**Land at, Lingards Road, Slaithwaite, Huddersfield, HD7 5HY – Discharge of conditions 4 (Phase II report), 5 (Remediation Strategy), 8 (Construction Environmental Management Plan), 9 (CEMP: Biodiversity), 10 (road condition survey), 11 (estate roads), 12 (Lingards Road footway), 13 (highway retaining walls), 14 (highway embankments), 15 (Stability Remediation Strategy), 16 (drainage infrastructure in highway), 17 (drainage scheme), 18 (flood routing), 19 (temporary drainage), 20 (Arboricultural Method Statement), 21 (bridge details), 22 (green retaining wall), 23 (Ecological Design Strategy), 24 (ecological measures), 25 (materials), 26 (footpath connections), 27 (landscaping), 28 (lighting), 29 (temporary waste arrangements), 30 (pedestrian improvements), 31 (pedestrian improvements) and 33 (cycle parking) of previous permission 2020/93954 for erection of 42 dwellings and associated works**

**Yorkshire Water object to the discharge of condition 17.**

Rev D Updated to suit latest planning layout / drainage design. Key added. 02.07.24 HH
Rev C Proposed drainage design updated 28.02.24 HN
Rev B Highlighted key watercourses and land drains. 28.07.23 GB
Rev A Update to suit latest planning layout Rev N. 23.01.23 HH

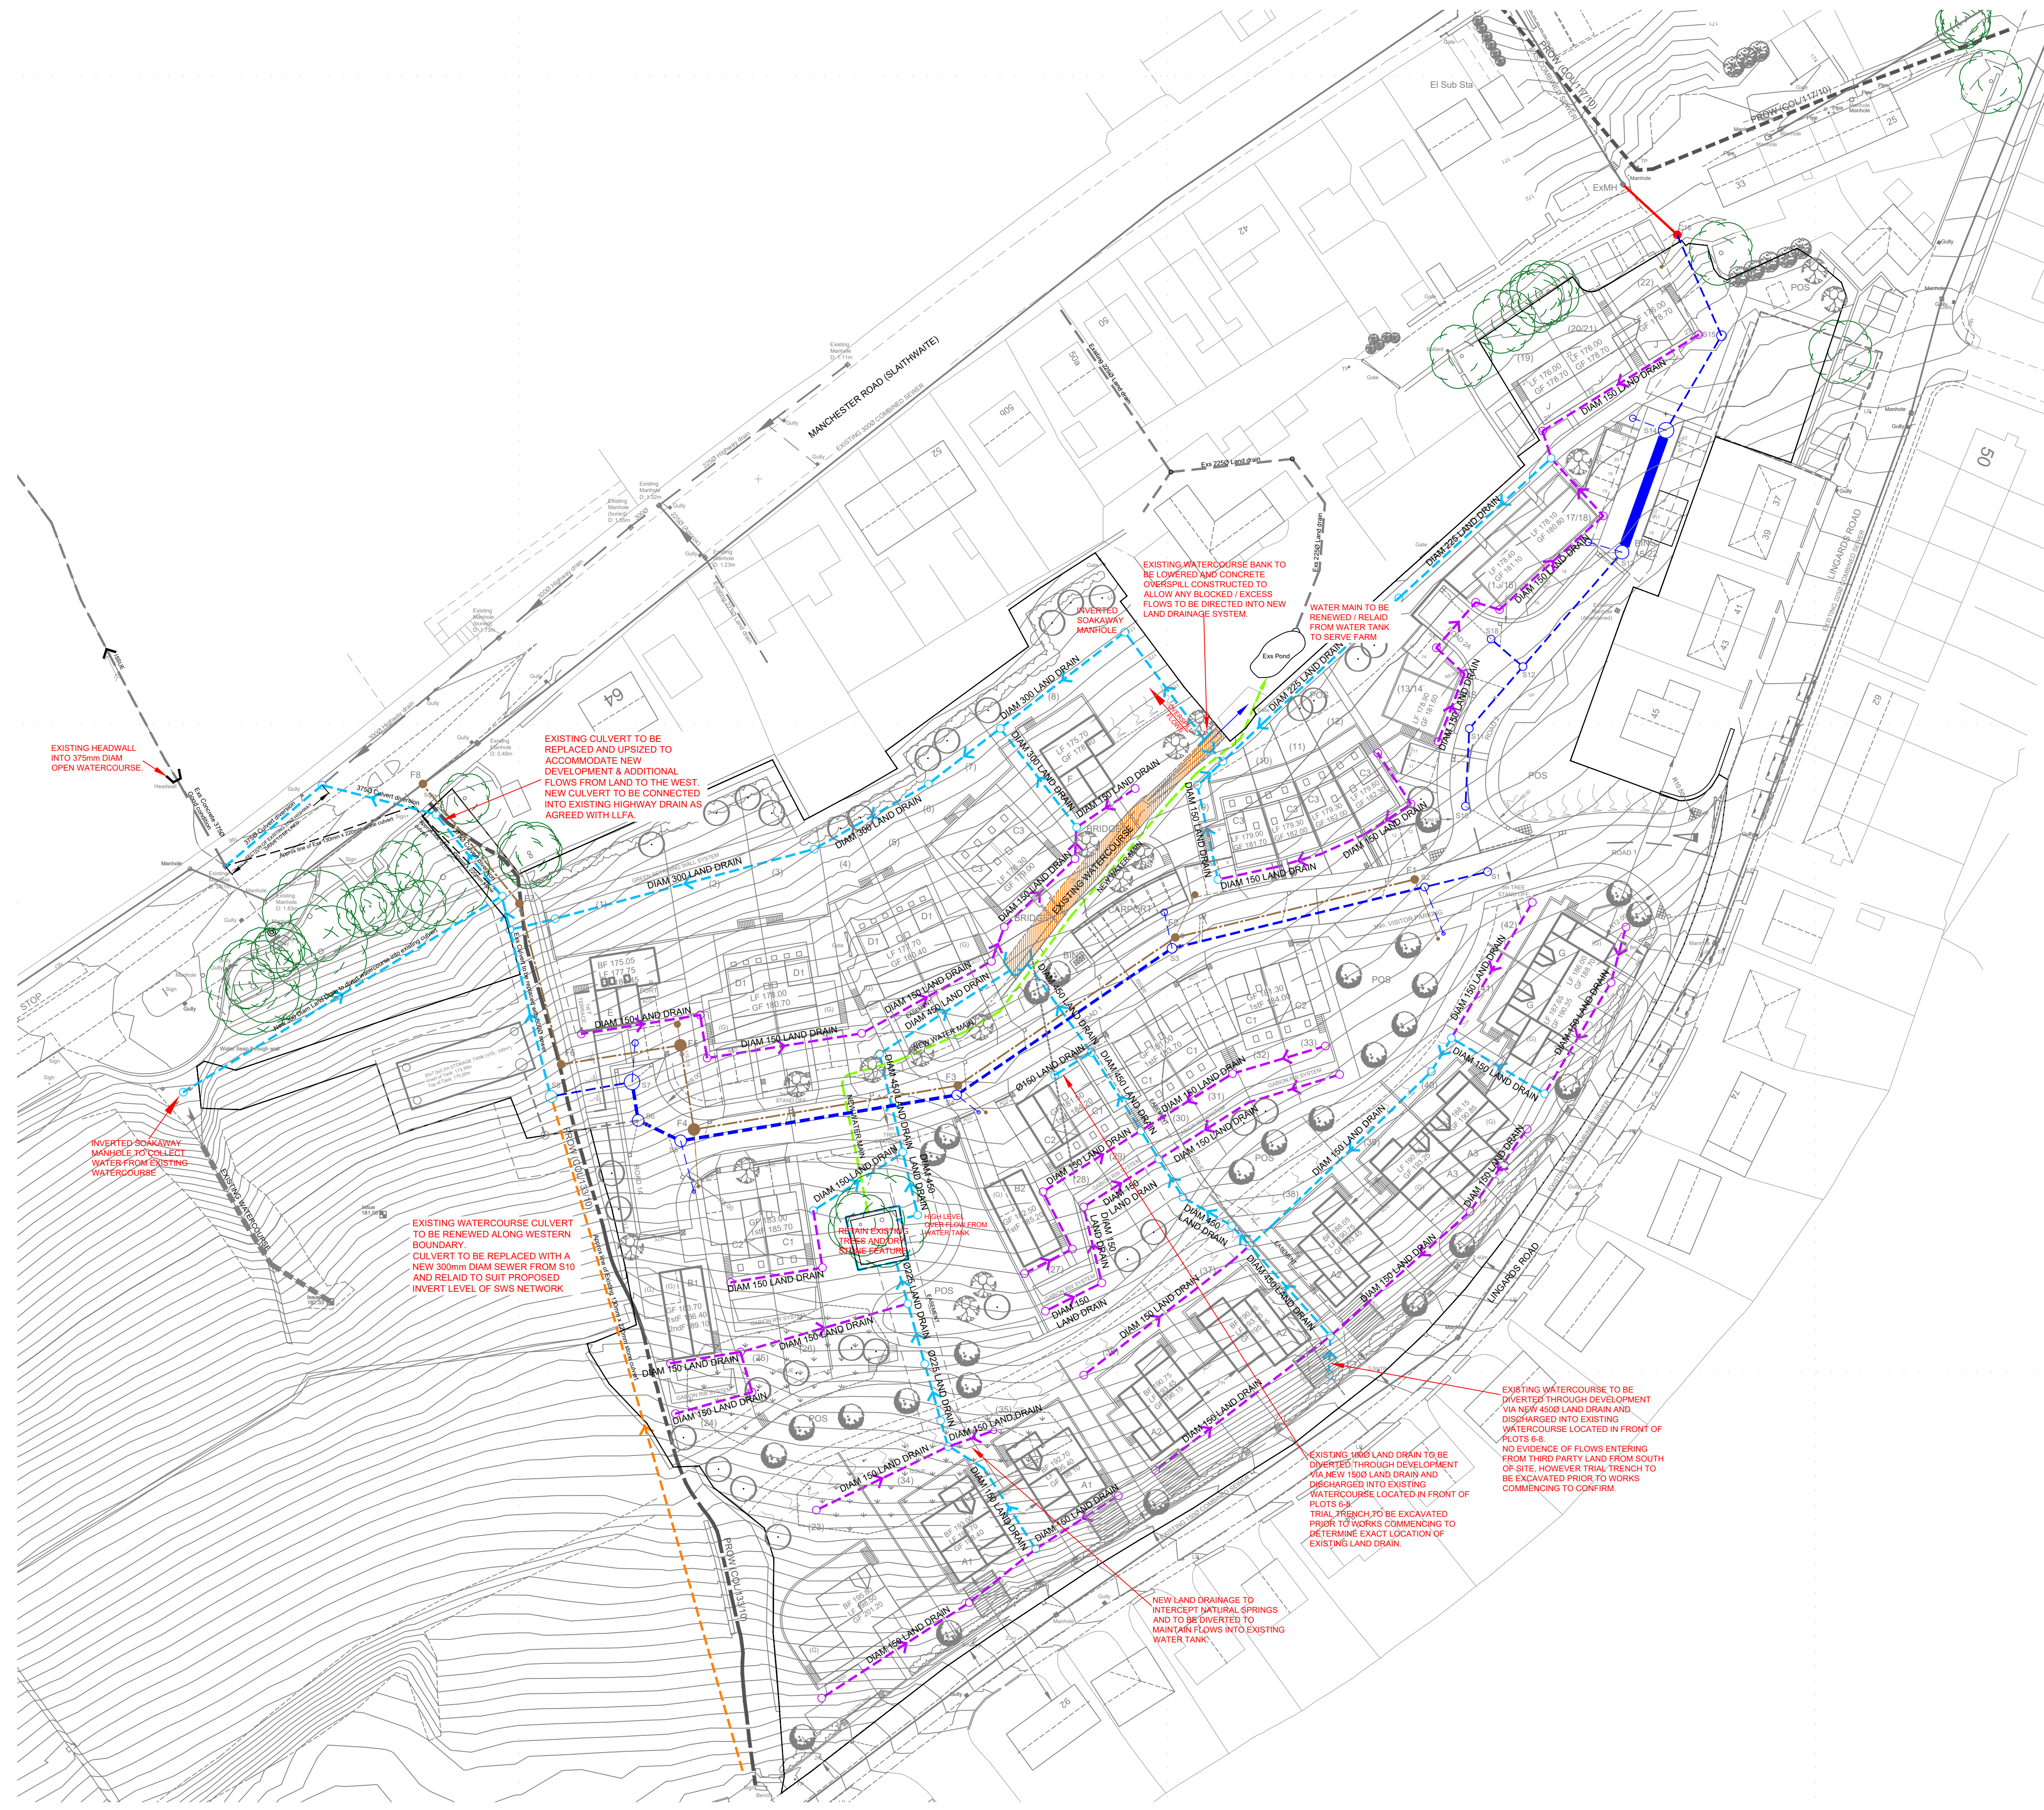
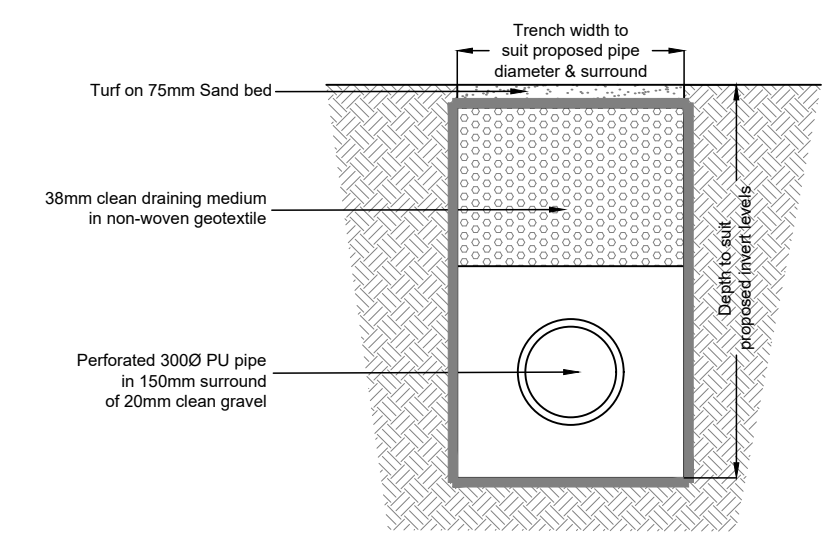
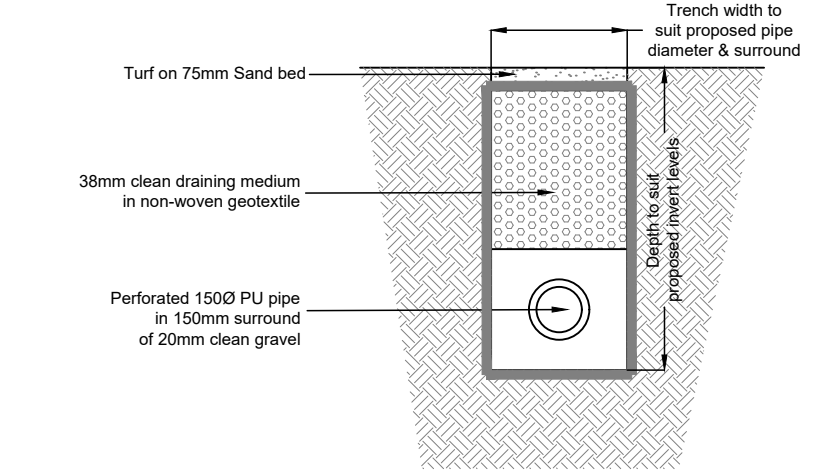
Drawing E19/7567/036D (Rev D dated 02/07/2024) prepared by Haigh Huddleston & Associates shows a discharge of surface water from Road 2 discharging to the public combined sewer network, despite the close proximity of a culverted watercourse/land drainage system. All surface water from the site should discharge to watercourse.
